REF: 23/03073/HYBRID

Location: Phase 2 SW Bicester Kingsmere Parcel R East
Of Ludlow Road Bicester

05 December 2023

Holding Objection

GROUND FLOOR PLAN

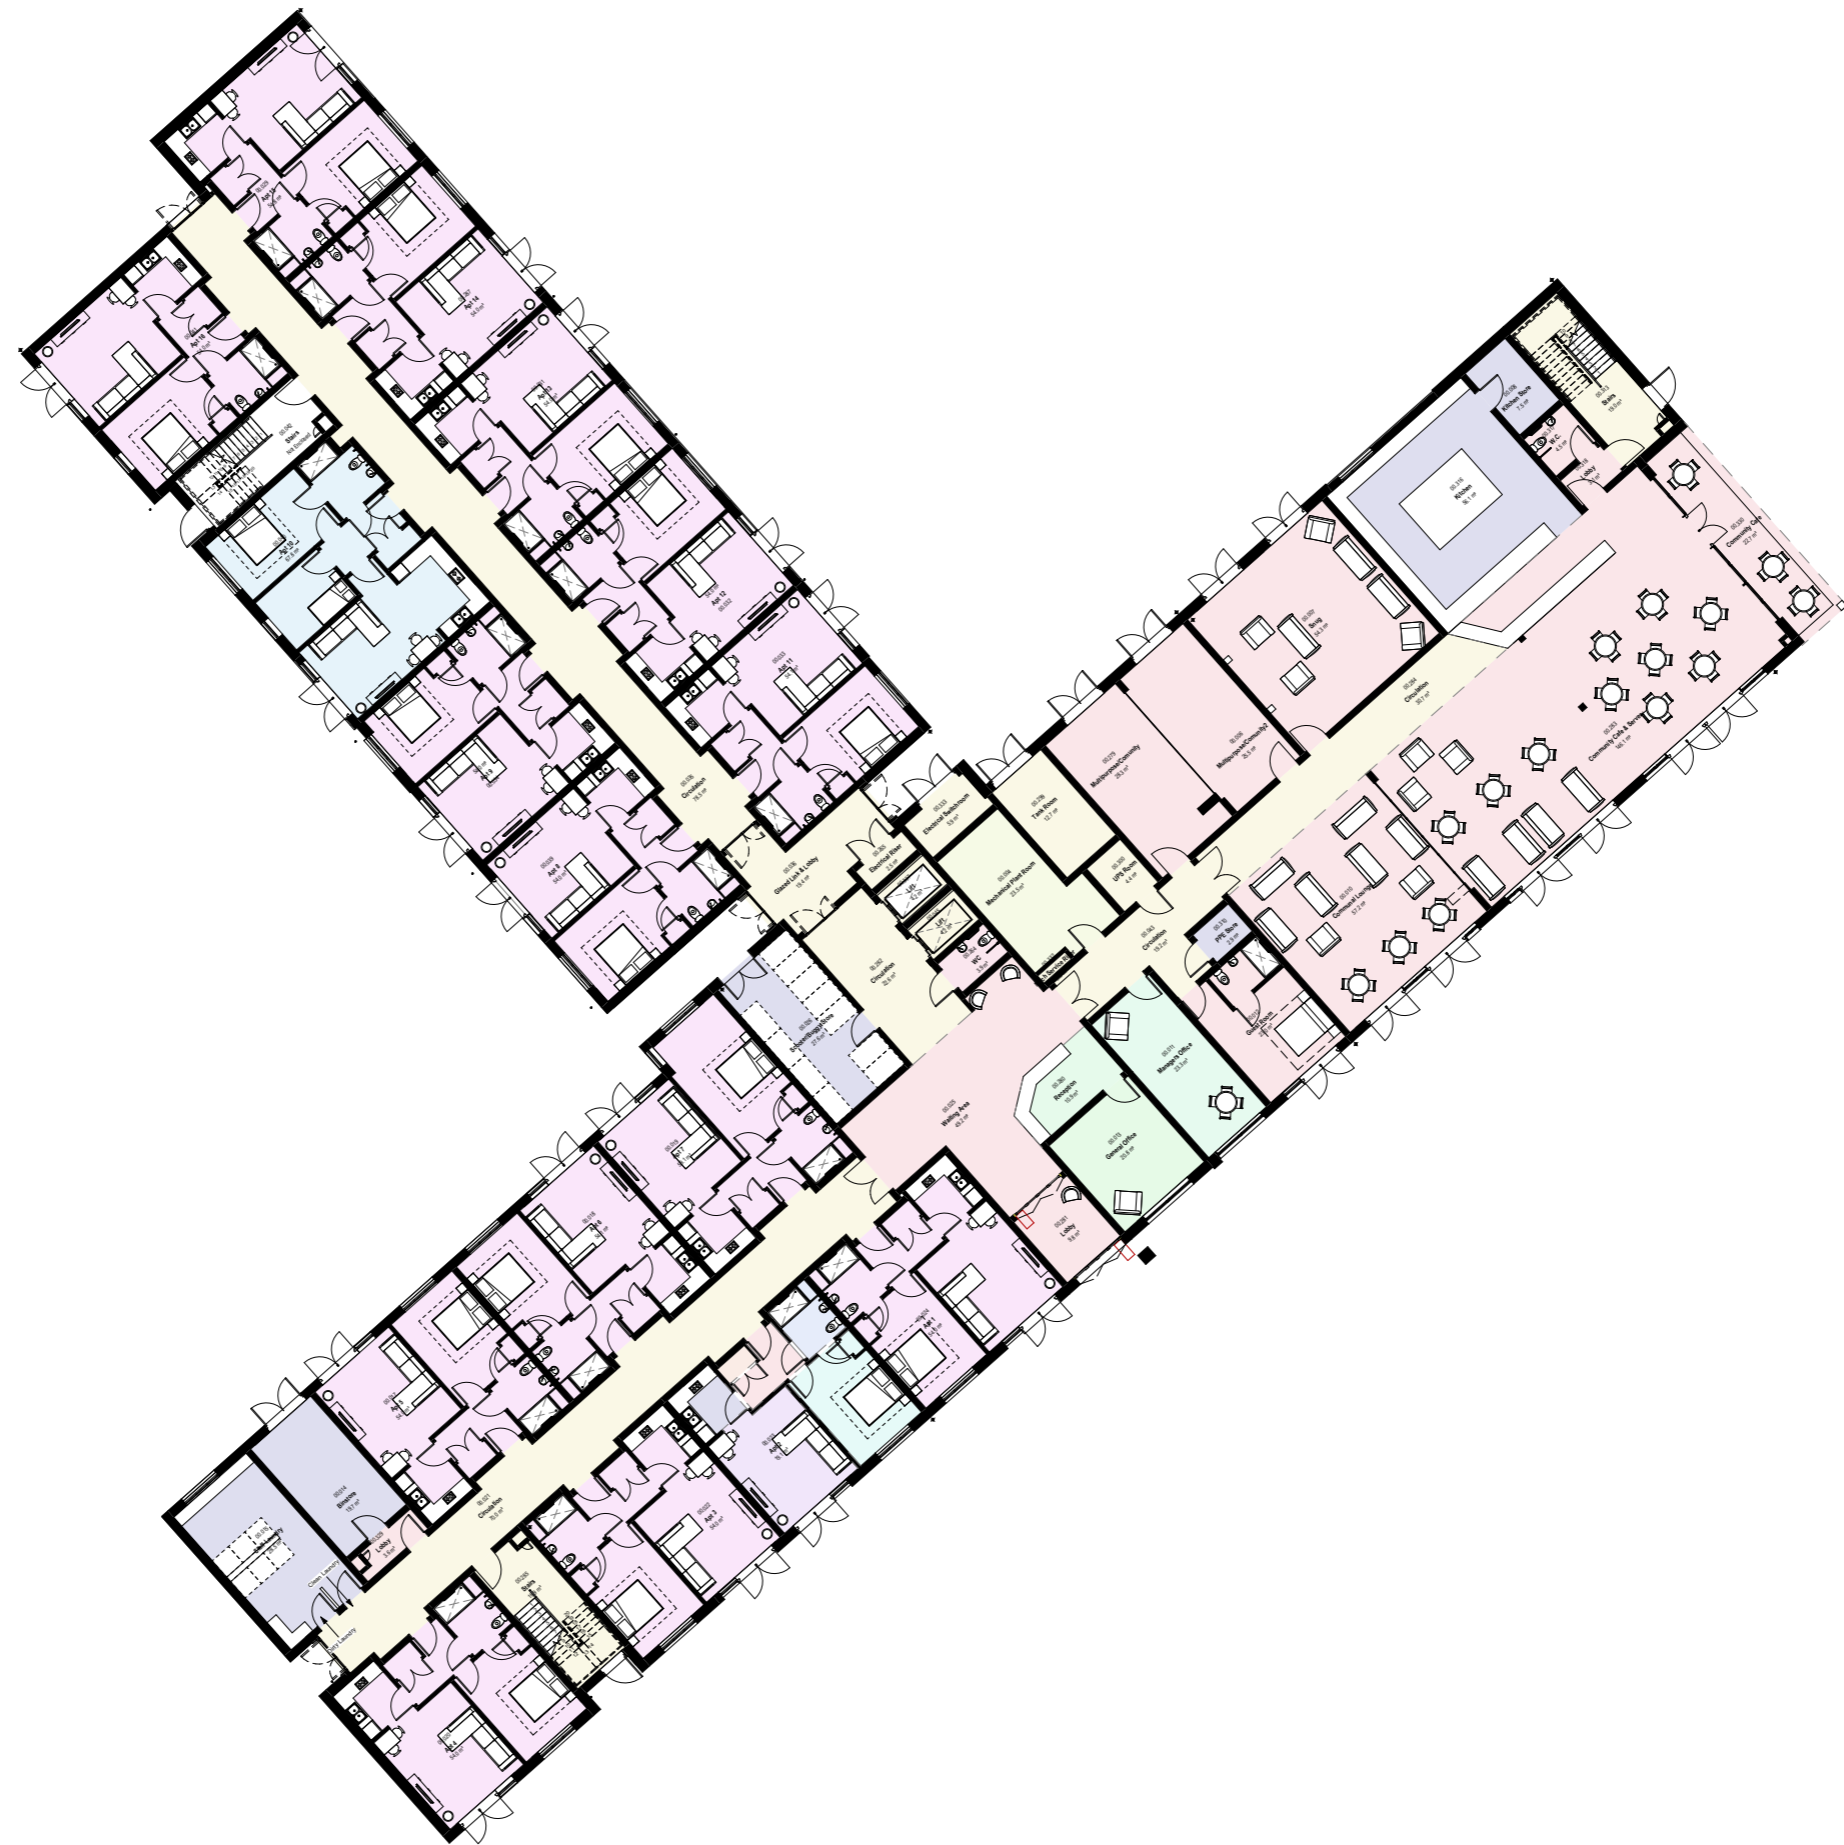
I have concerns that there is no clear and easily identifiable primary entrance for the residential block, with several points of access that are closer and more convenient to use for those arriving in a vehicle or on bike.

The staffed reception area should provide security to the building by providing oversight of movement to and from the building, however due to its central location it is unable to fulfil this role. Considering the nature of this development and the vulnerabilities that will be present in its residents, it is of fundamental importance that building security is a primary consideration in the design, and an additional layer of defence is required. This is via the provision of a reception with staff able to oversee all movements to and from the residential element of the building. Not only does this reduce the opportunities and likelihood of offenders gaining access to the building, it also gives staff the opportunity to observe residents coming and going, which is important in a care setting where residents with dementia may be residing.

Failing to provide a single clear and easily identifiable entrance gives an intruder a legitimate excuse for being in an area that they should not, as they could claim they were trying to locate the reception area. The number of entrances and exits on the ground floor create excessive permeability, where opportunities for tailgating into the building unnoticed are increased, whilst the likelihood of apprehending an offender is reduced as they would have multiple options for escape.

The provision of publically accessible space increases these concerns, as you are inviting non-residents onto the site to make use of facilities such as the bistro, which as mentioned above potentially gives an offender a legitimate excuse for being where they shouldn't.

I have concerns that the deeply recessed and poorly lit alleyway which provides access to a lobby and the bin stores creates vulnerability, whereby an offender could make concealed entry attempts to gain access to the building. The residential dwelling with a window into this alleyway is left vulnerable also.

I recommend this development is provided an appropriately located and clearly identifiable reception to allow staff to monitor movements to and from the site. The reception should be made a prominent feature through the location, lighting, signage and fenestration surrounding the entrance. Excessive permeability must be avoided, and the reception staff should be able to see persons entering and exiting cores and private corridors once through the main entrance.
